Cowal Gold Underground Development Groundwater Assessment Peer Review

NSW Department of Planning
Industry and Environment

20 May 2021
(Final Review)

Middlemis H (2021). Cowal Gold Underground Development Groundwater Assessment Peer Review (Final). Prepared by HydroGeoLogic for NSW Department of Planning, Industry and Environment. 20 May 2021.

Figure 14: Pit Dewatering and Lake Cowal Levels

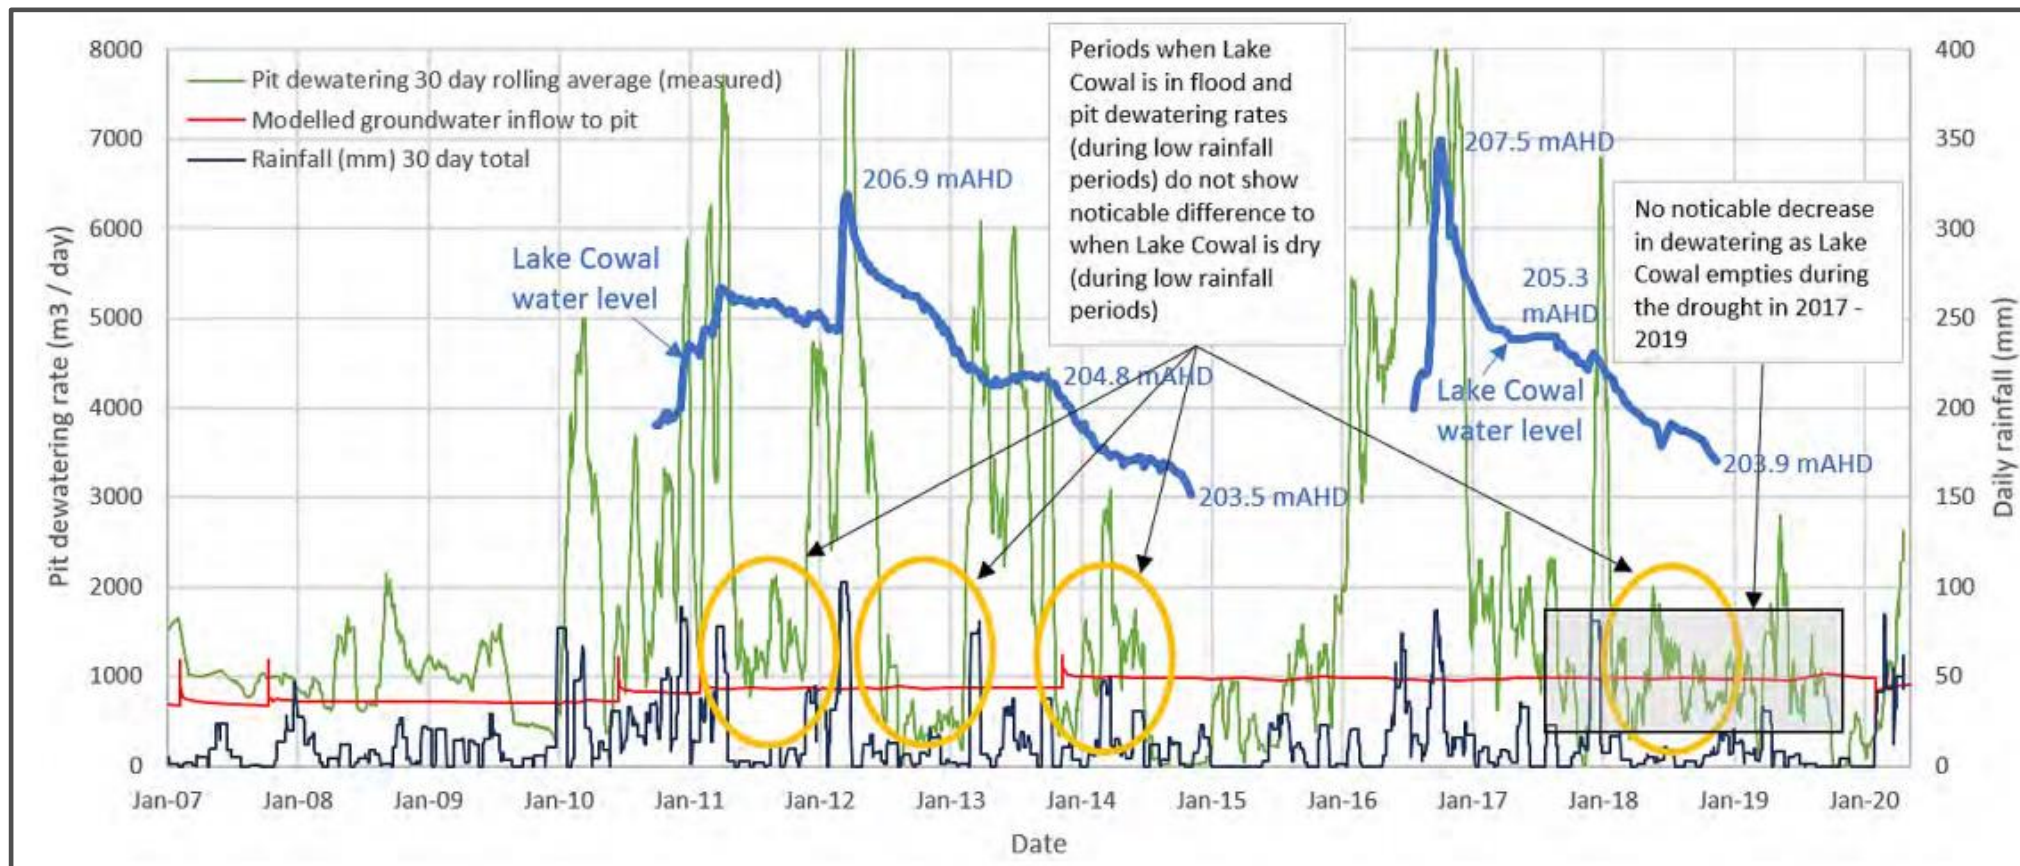
The modelled open pit ‘groundwater inflow’ rates are typically around 0.8-1.0 ML/day (red line in Figure 4, next page), and are adequately consistent with the reported volumes during low rainfall periods (yellow shapes in Figure 4), such as 2018-2020. The report (Coffey 2020a) shows that the recorded pit dewatering volumes are quite variable (green line in Figure 4), ranging from around 1 ML/day or less during low rainfall periods, up to 8 ML/day during very wet periods (eg. 2010-2012, 2014, 2016).

The report suggests erroneously that recorded pit dewatering does not correlate well with rainfall, as it is clear from Figure 4 that pit dewatering historically increased greatly during wet periods, typically by a factor of 4 or 5 times, and sometimes up to 8 times. The response to submissions (EMM 2021b, item 4) provides a reasoned clarification that groundwater inflows are less variable than pit dewatering rates, and it is inflows that do not correlate strongly with rainfall.

As requested at the initial review stage, the proponent subsequently provided further detail on the components of 'groundwater inflow to the pit' in the response to submissions reports (EMM 2021a, section 4.1.1), and also in Addendum 1 (EMM 2021b, item 3) and Addendum 2 (EMM 2021c, sections 4.1 and 4.9.6), which also provided at item 4 a cogent explanation as why it is acceptable for the model to be benchmarked to 'groundwater inflows' only during dry periods.
